PLANNING AMENDMENT

H13/1173/98

PROPOSED GARAGING + GARDEN STORE
INCL VEHICULAR ACCESS

Amendment: Revised turning facility (Drawing No. 980502/02A)

SITE LAYOUT AS PROPOSED
ENTRANCE GATE DETAILS

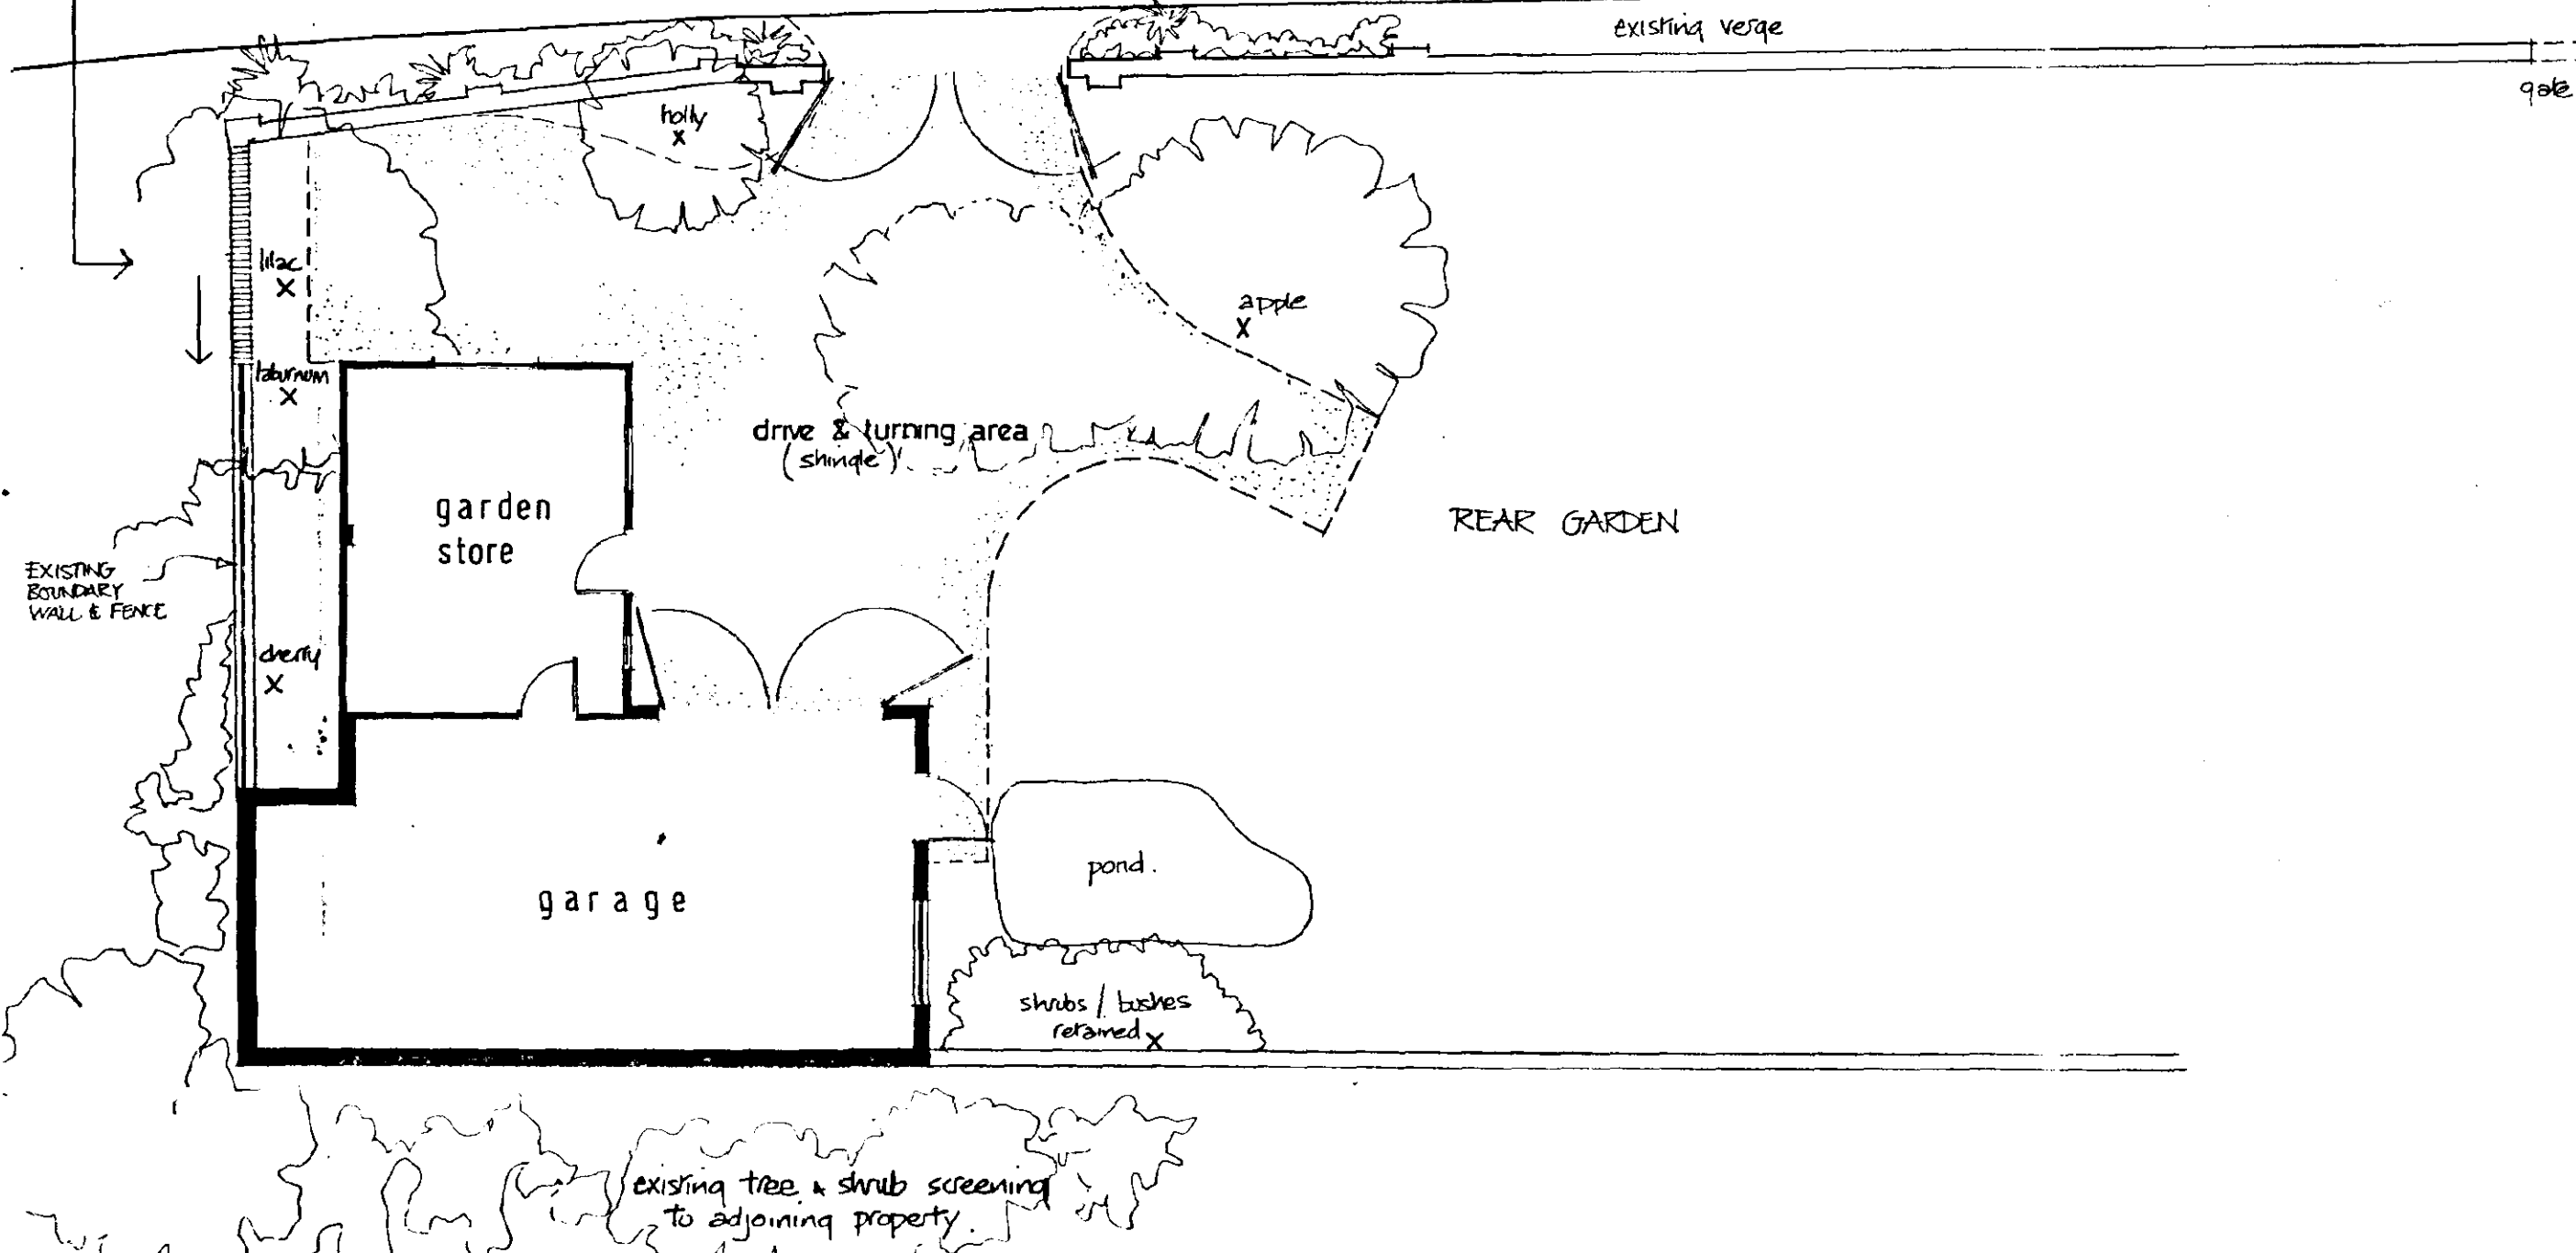
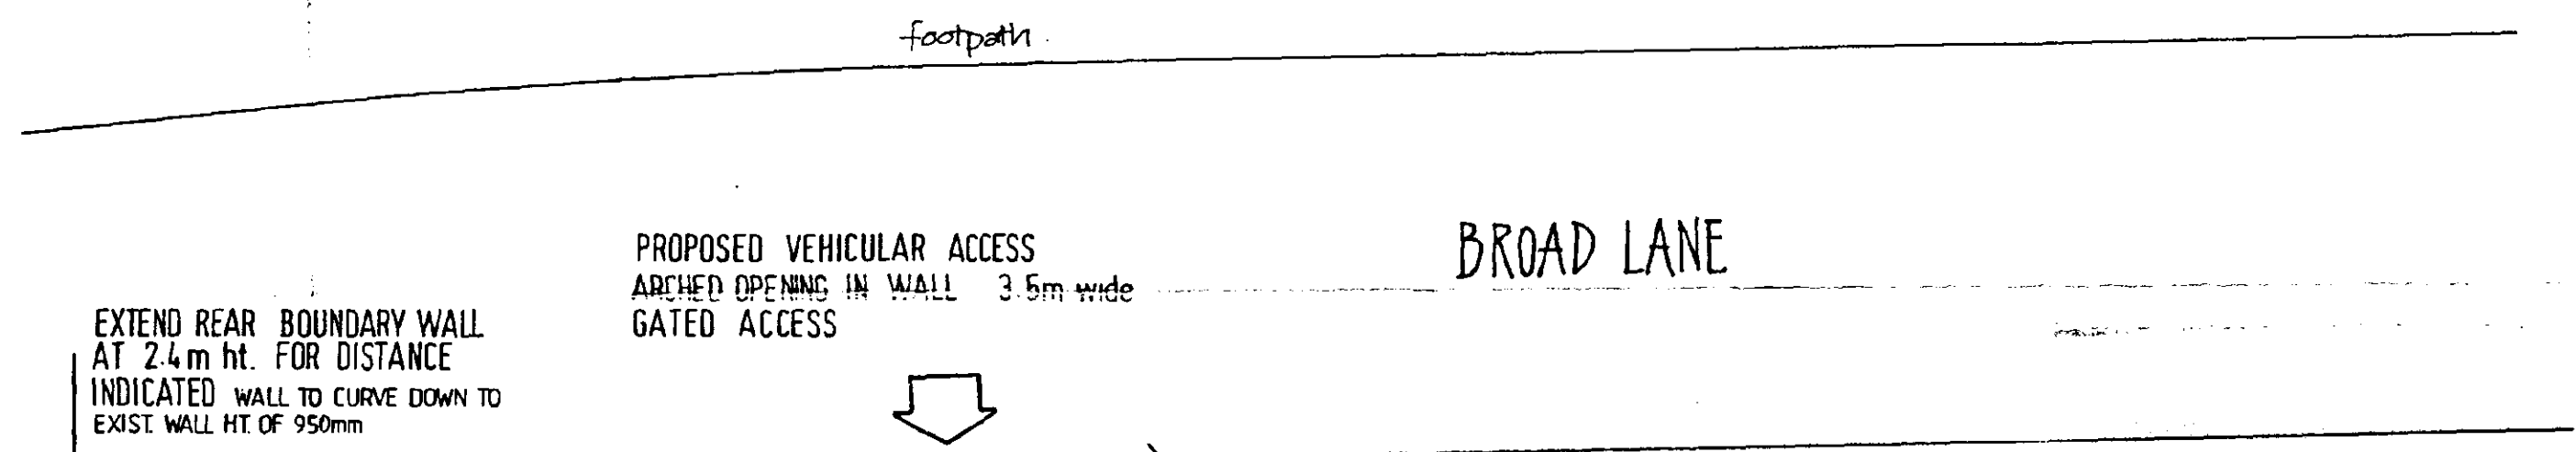
~~REMOVED~~
REVISED TURNING FACILITY
